WEST SUSSEX COUNTY COUNCIL CONSULTATION

TO:	Arun District Council FAO: Simon Davis
FROM:	WSCC - Highways Authority
DATE:	14 February 2023
LOCATION:	Land East of Eastmere House, Eastergate Lane, Eastergate, PO20 3SJ
SUBJECT:	BN/26/22/PL Construction of 1 No. two storey detached dwelling house on existing paddock. This application is a Departure from the Development Plan and is in CIL Zone 3 and is CIL Liable as new dwelling.
DATE OF SITE VISIT:	N/A
RECOMMENDATION:	Advice
S106 CONTRIBUTION TOTAL:	N/A

Image 3: proposed block plan (n.t.s.)

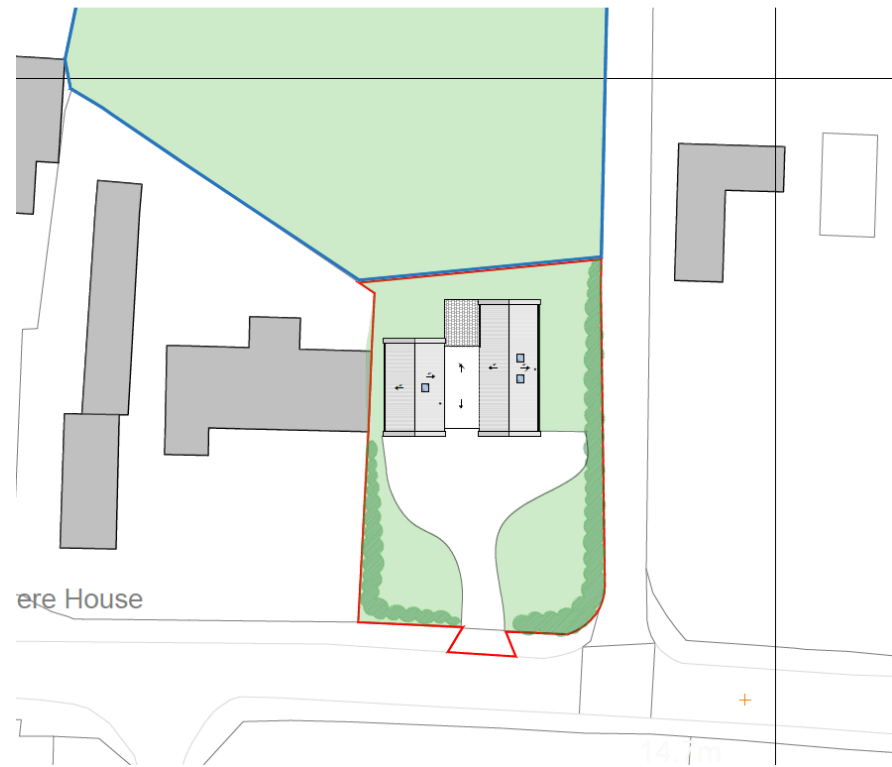
Under Arun Parking Standards, the LHA would expect a dwelling of this size and location to provide at least three car parking spaces. The plans demonstrate a driveway fronting the proposed dwelling, which appears of suitable size to accommodate three car parking spaces. On-site turning has also been demonstrated to the satisfaction of the LHA.

Regarding cycles, the applicant has demonstrated a cycle store, which appears of suitable size to accommodate at least two cycles in accordance with Arun Parking Standards.

No part of the development shall be first occupied until covered and secure cycle parking spaces have been provided in accordance with plans and details to be submitted to and approved by the Local Planning Authority.

No part of the development shall be first occupied until the vehicle parking and turning spaces have been constructed in accordance with the approved plan. These spaces shall thereafter be retained for their designated use.

Drawing Status	Final
Client	Mr O. Strudwick
Project	Eastmere House, Eastergate Lane
Drawing Title	Site Overview and Visibility Splays
Scale	As Shown
Date	Jan 23
Drawn By	SMO
Checked	EJD
Drawing No.	2022-6510-001
Rev.	-

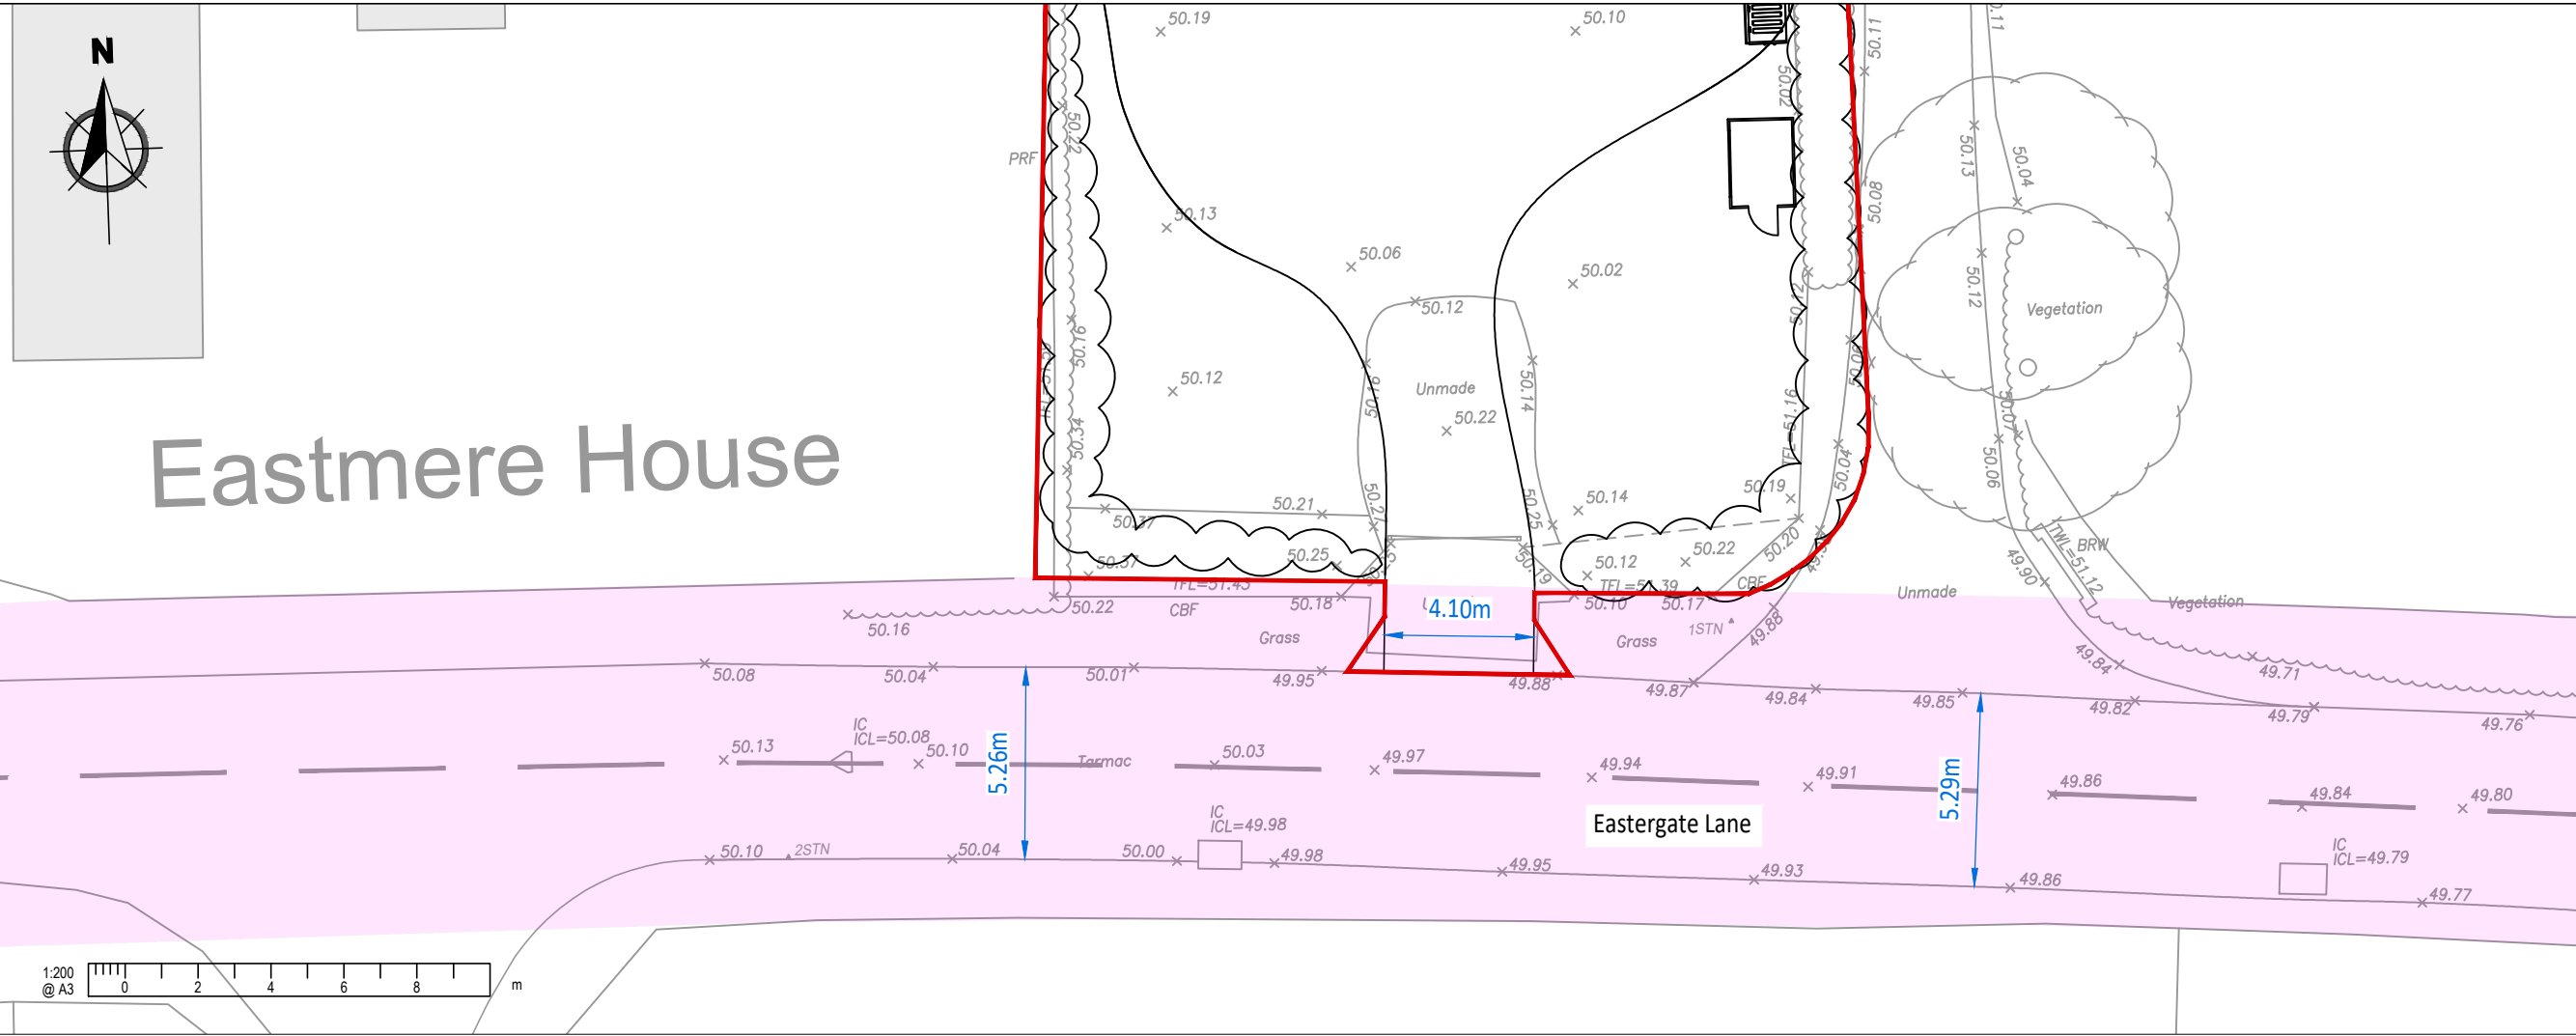
The applicant has submitted seven-day speed survey data, as requested by the LHA. The data shows 85th percentile speeds to be 39.3 mph Eastbound and 37.7 mph Westbound in this location. Visibility splays of 2.4m x 98.1m to the west and 2.4m x 91.6 to the east have been demonstrated to reflect the recorded 85th percentile speeds, to the satisfaction of the LHA.

No part of the development shall be first occupied until visibility splays of 2.4 metres by 98.1 metres to the west and 2.4 metres by 91.6 metres have been provided at the proposed site vehicular access onto Eastergate Lane in accordance with the approved planning drawings. Once provided the splays shall thereafter be maintained and kept free of all obstructions over a height of 0.6 metre above adjoining carriageway level or as otherwise agreed.
